CITY OF ALBUQUERQUE

August 5, 2024

**Re: Opus Transport Apartments
Traffic Impact Study (M15D023H)**
Engineer's Stamp 7-10-24
Via email jroberts@tierrawestllc.com

The subject Traffic Impact Study (Study) received on July 11, 2024, has been reviewed by the City of Albuquerque Planning Development Transportation Section. The City has the following comments to be included in the Final TIS.

Figure 4: Proposed Striping and Intersection Mitigation

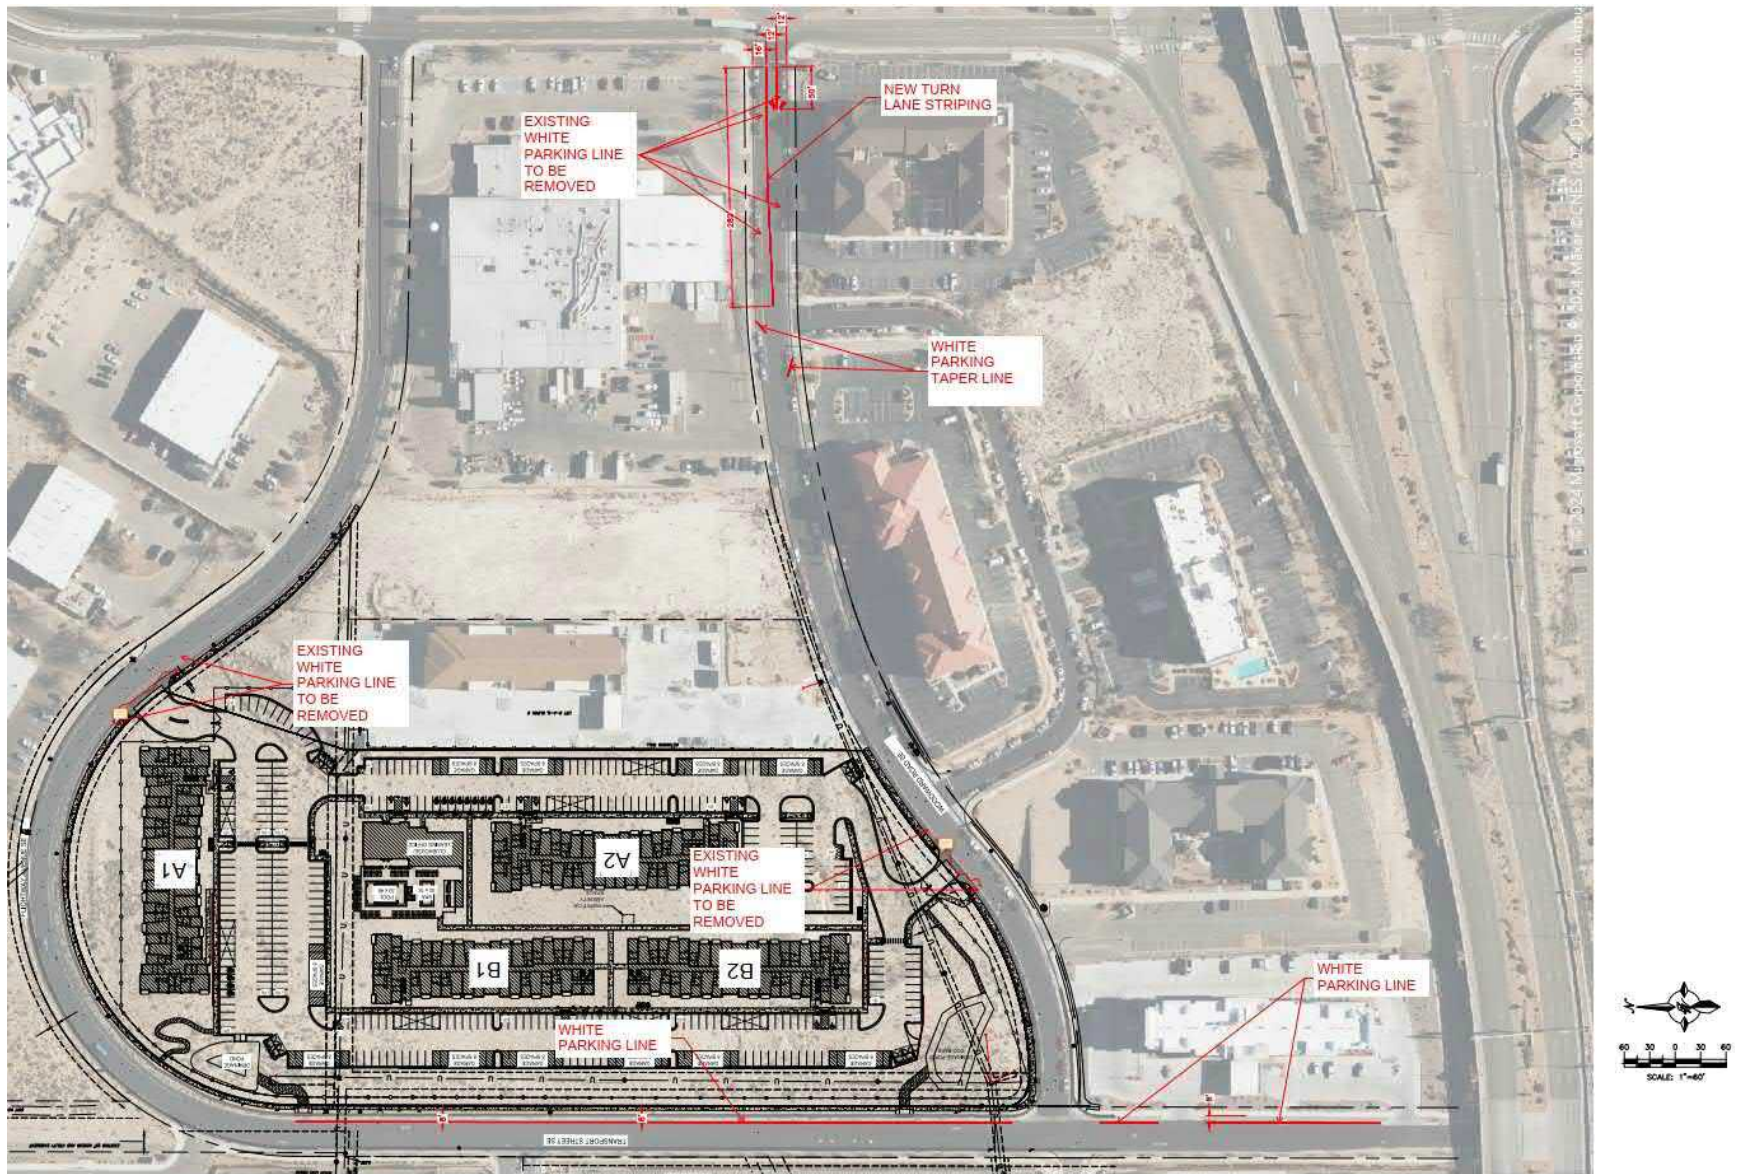
1. Please include the striping exhibit V2.
2. Revise the analysis at Woodward Rd and University Blvd using eastbound right and left turn lanes.
